DRB Application No.: 05DRB-01687 (P&F)
Project Name: EL POTRERO PROPERTIES
Agent: Isaacson & Arfman PA

CITY OF ALBUQUERQUE
Planning Department
November 9, 2005
DRB Comments

PROJECT # 1004434 APPLICATION #05-01687

RE: Tract A, El Portero Properties/minor pp & fp

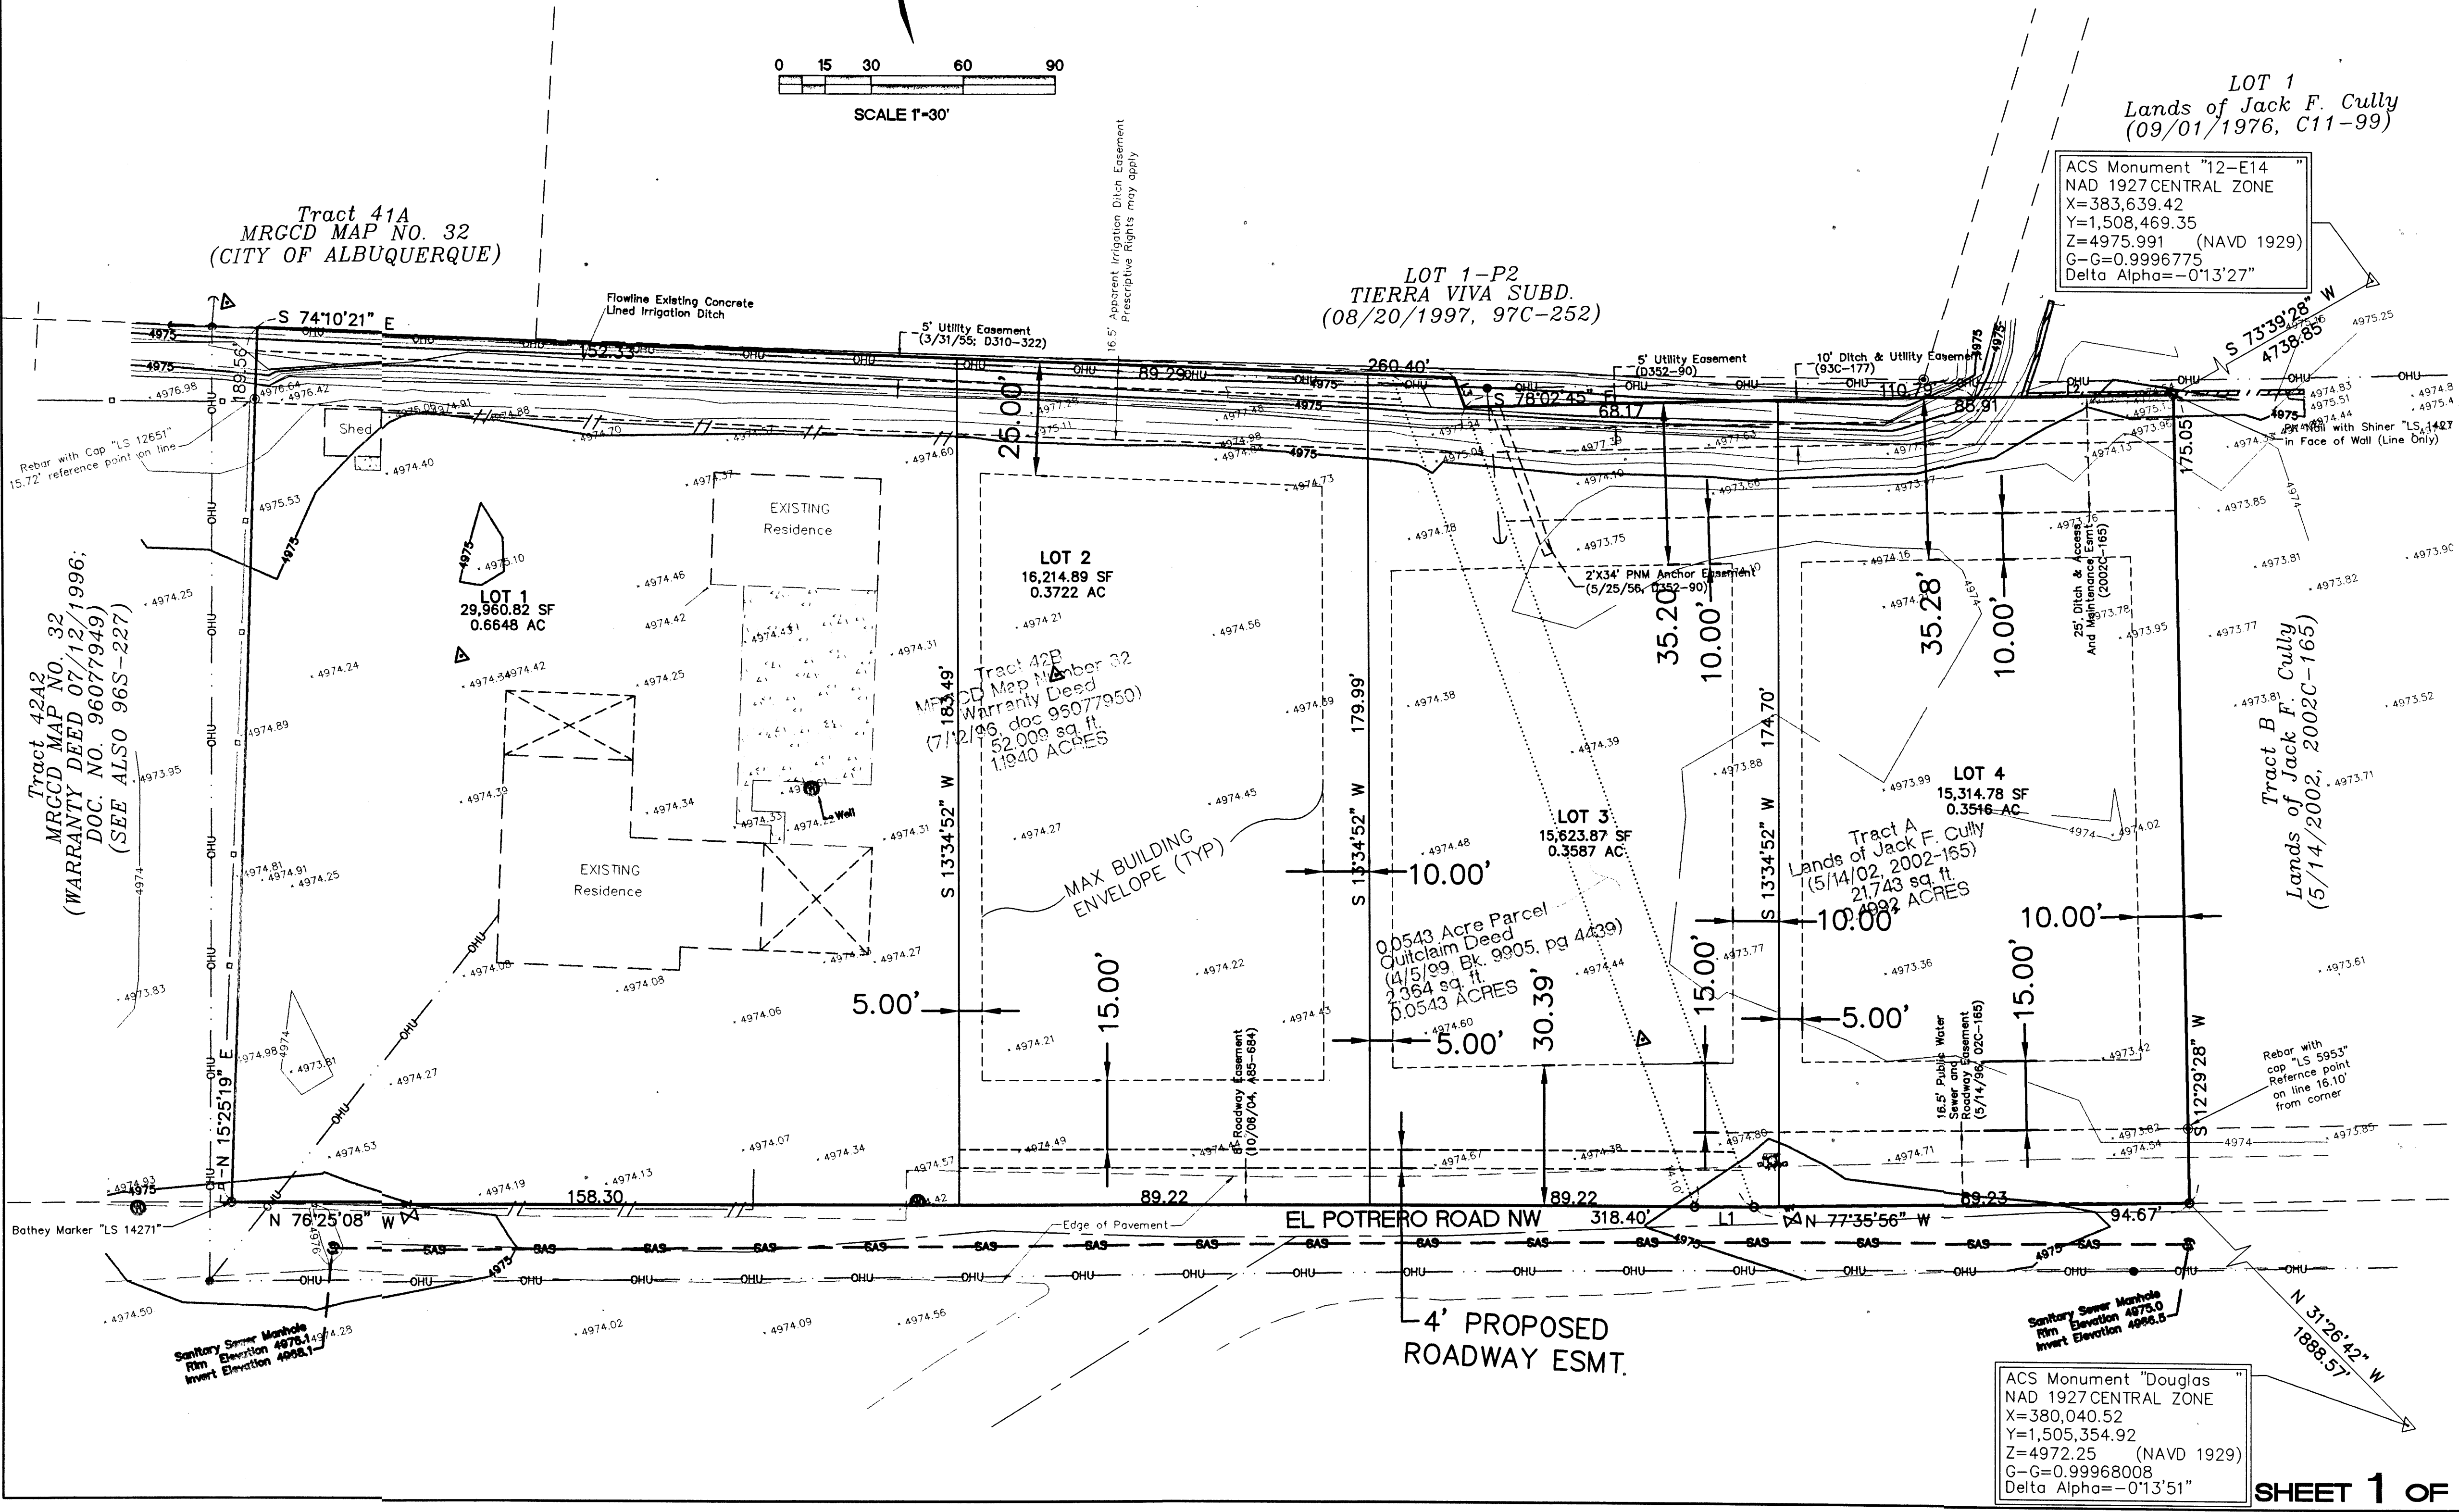
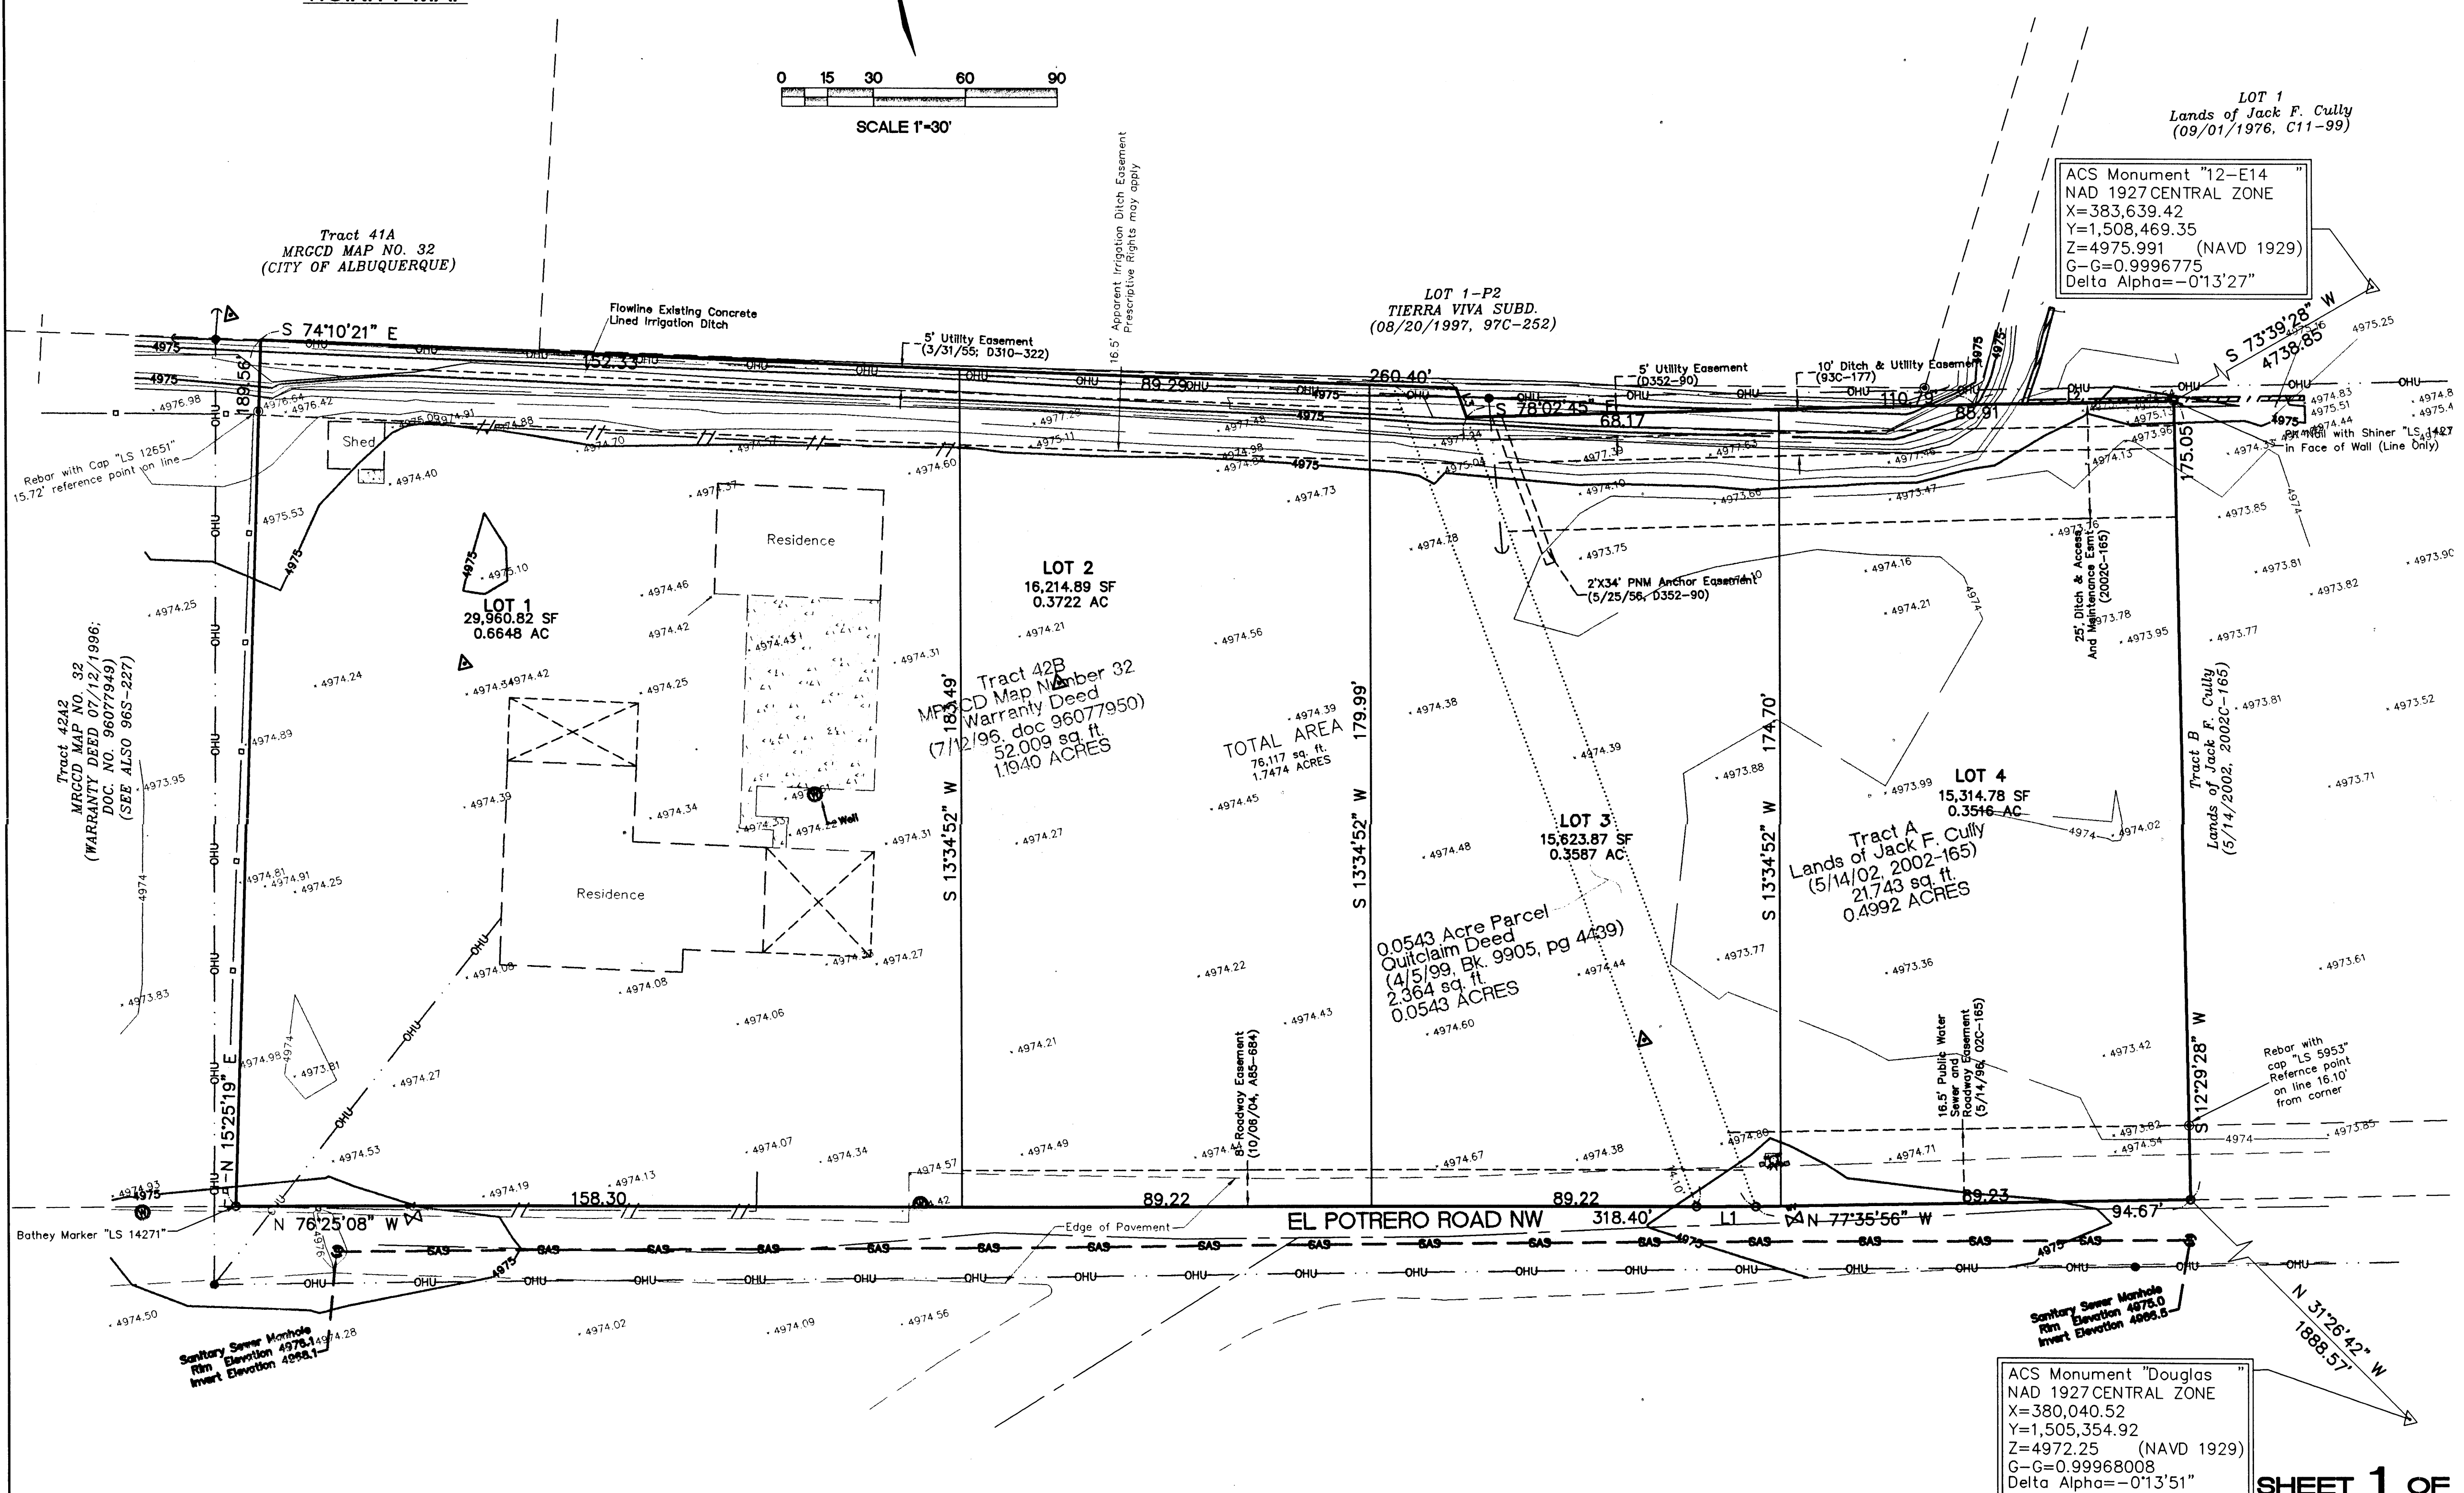
The sketch plat shows two existing structures on the proposed Lot 1.
Will one of these residences disappear?
